**Catchment Management
Authority**
Hunter-Central Rivers

Subject: State Significant Infrastructure – Hexham Relief Roads (SSI-4992)

I refer to your correspondence of 7 August 2012 seeking comments from the Hunter-Central Rivers Catchment Management Authority (CMA) on the Environmental Impact Statement (EIS) for the above proposal. The CMA has reviewed the EIS documentation against the Catchment Action Plan (CAP) and provides the following comments.

Figure 4.4c

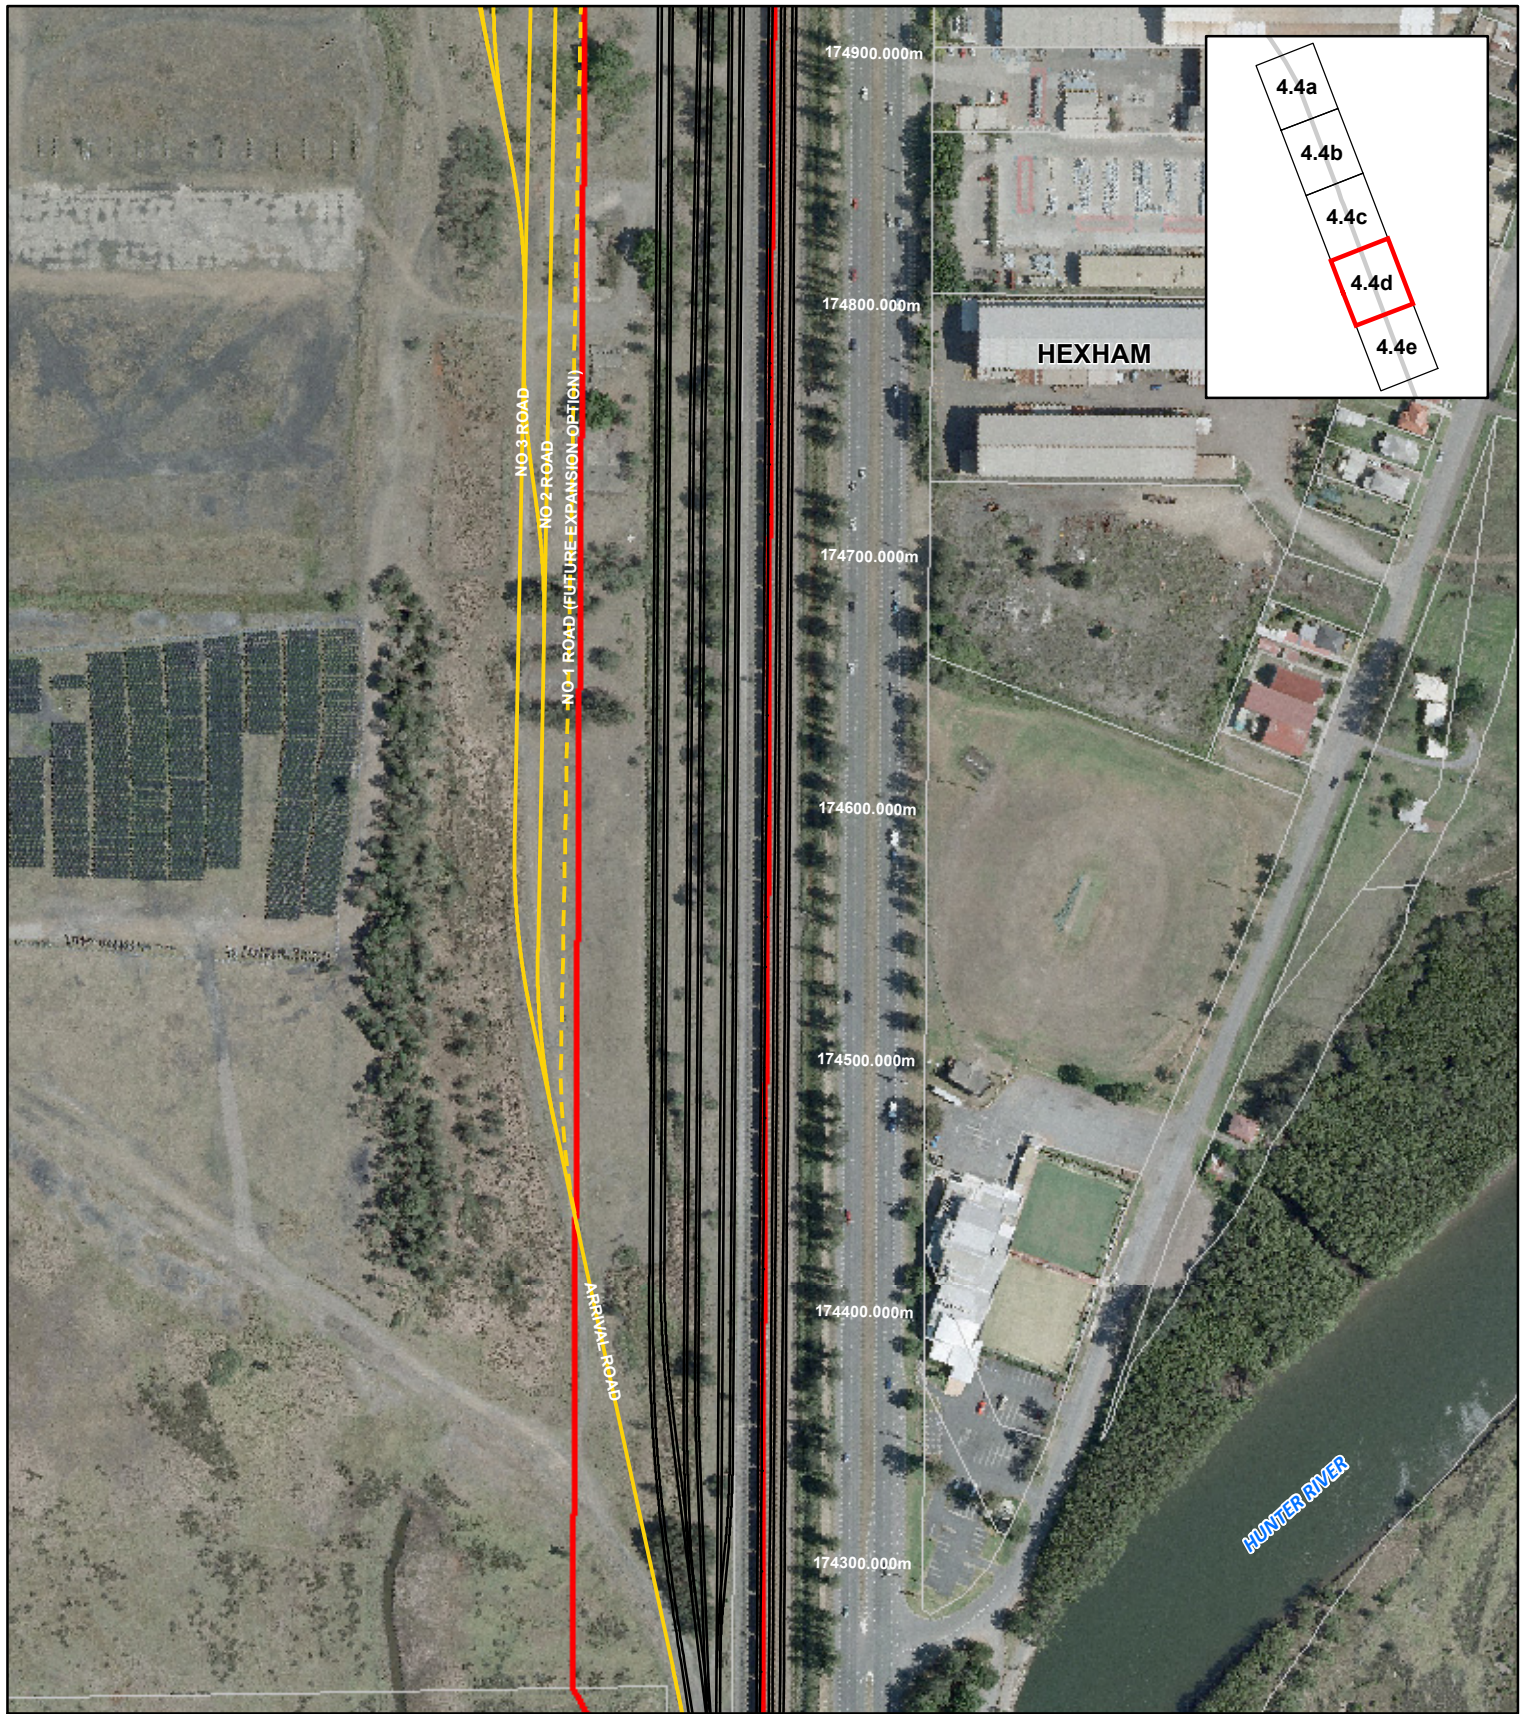
The CMA notes that the amount of offset required could be reduced by altering the location of some of the infrastructure including the office and amenities block, carpark and turntable areas to adjacent sites that are already cleared of native vegetation (Fig. 4.4c). As the EIS does not contain adequate details of a specific offset package, the CMA is unable to properly assess or support the proposal at this time.
